# A303 Amesbury to Berwick Down

## Deadline 2 8.5 Statement of Common Ground – National Trust

**STATEMENT OF COMMON GROUND – National Trust**

<b>Version</b>	<b>Date</b>	<b>Status of Version</b>
Rev 0	03.05.2019	Deadline 2 Issue

Drawing Title
RIGHTS OF WAY AND ACCESS
PLANS
REGULATION 5(2)(k) & 5(2)(o)
KEY PLAN

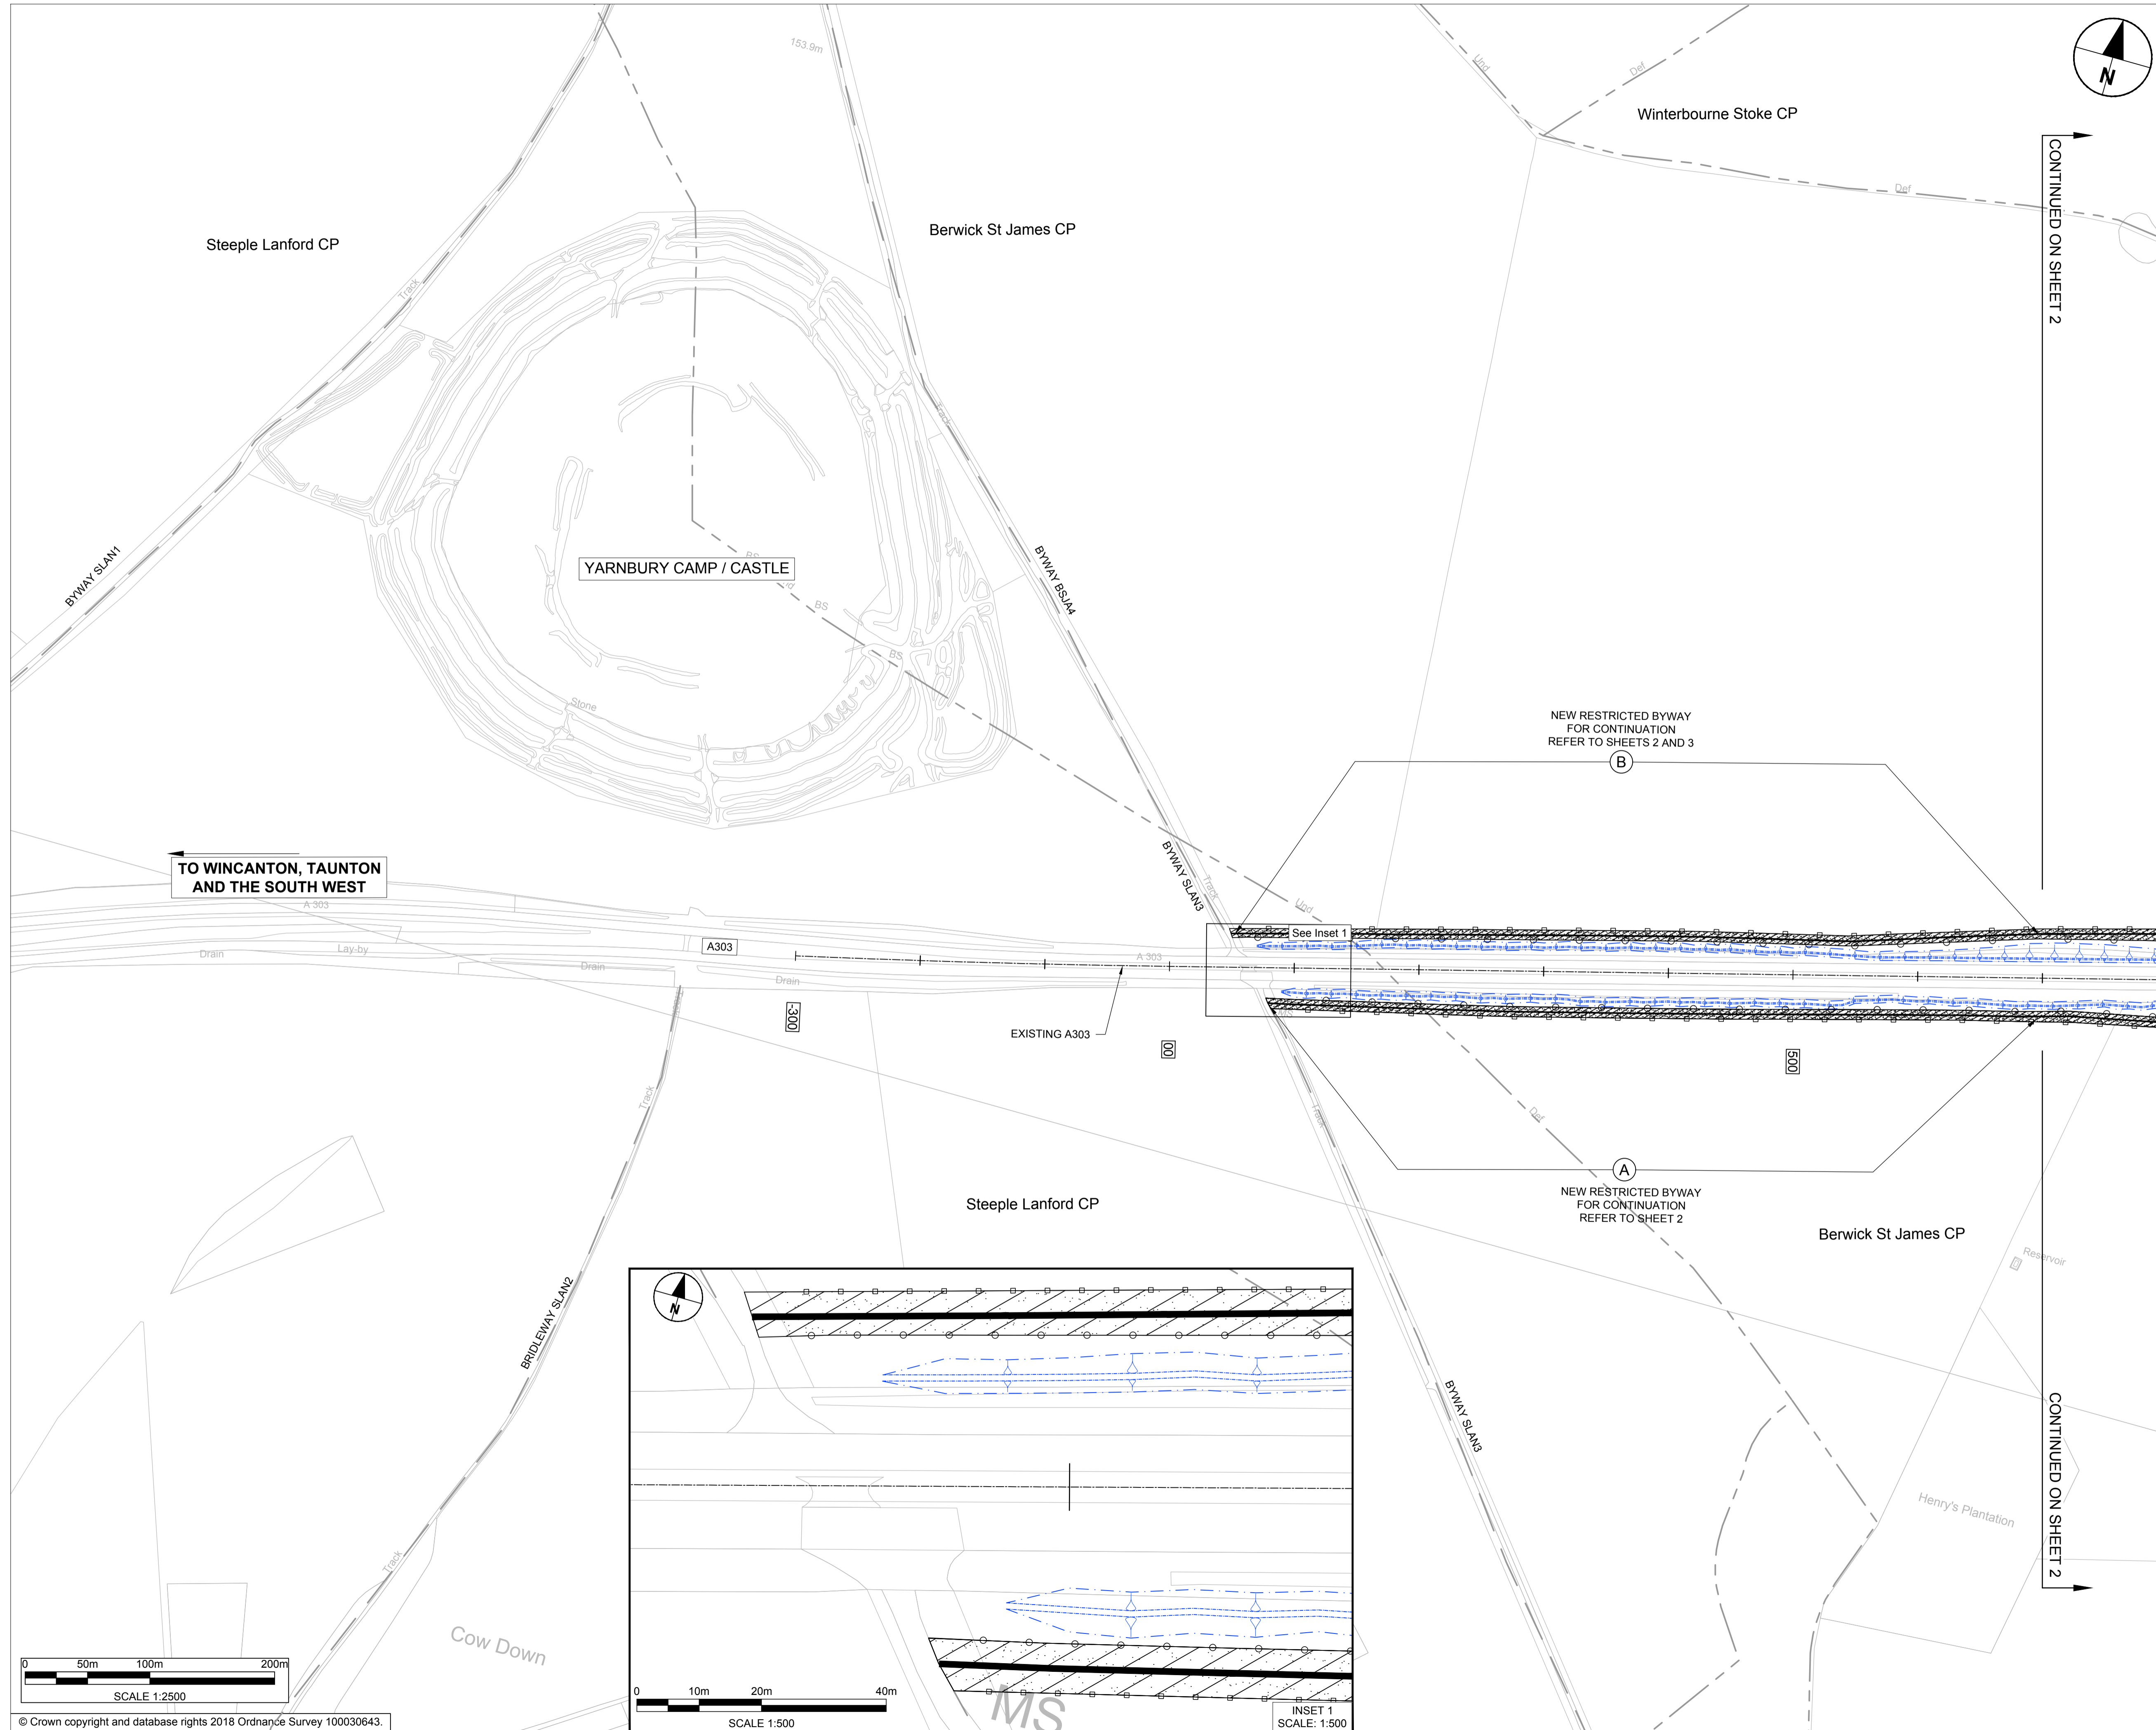
4.4	[RR-2344]	5.1.3	Rights of Way	The overall Rights of Way strategy needs further consideration, especially in regards to the proposed treatment of the current A303 and the redundant portion of the A360 and other NMU (Non-Motorised User) access post scheme construction.	The existing road surface of the existing A303 and A360 would be reduced to a width of no more than 4m to provide a level, durable surface for non-motorised users including those needing mobility aids, and those vehicles permitted to use the route such as agricultural and maintenance vehicles. It would be treated with a new visually recessive surface. The surplus areas of redundant road surface would be replaced by chalk grassland (Section 2.3.56(d) in the Environmental Statement [APP-040]). The design of these elements will be developed through the detailed design process in consultation with National Trust.	Under Discussion

4.5	[RR-2344]	5.1.4	Byways	The status of the current BOATs (Byways Open to All Traffic) require further consideration to ensure compatibility with the overall configuration of the other forms of access and Rights of Way within the WHS post scheme construction.	Changing the status of the existing BOATS is beyond the scope of the Scheme and is a matter for Wiltshire Council to consider as the local highway authority. Highways England wishes to ensure that the Scheme is integrated	Under Discussion

<p>within the existing byway network and, where the opportunity exists, create legacy benefits for non-motorised users in accordance with its Strategic Business Plan and Road Investment Strategy, which are aligned with Government policy to encourage walking, cycling and horse-riding through national and local policies and plans. The new public rights of way measures proposed along the Scheme would not only maintain, but would also considerably enhance the existing public rights of way network, significantly improving connectivity for non-motorised users, as illustrated on the Rights of Way and Access Plans [APP-009].</p>
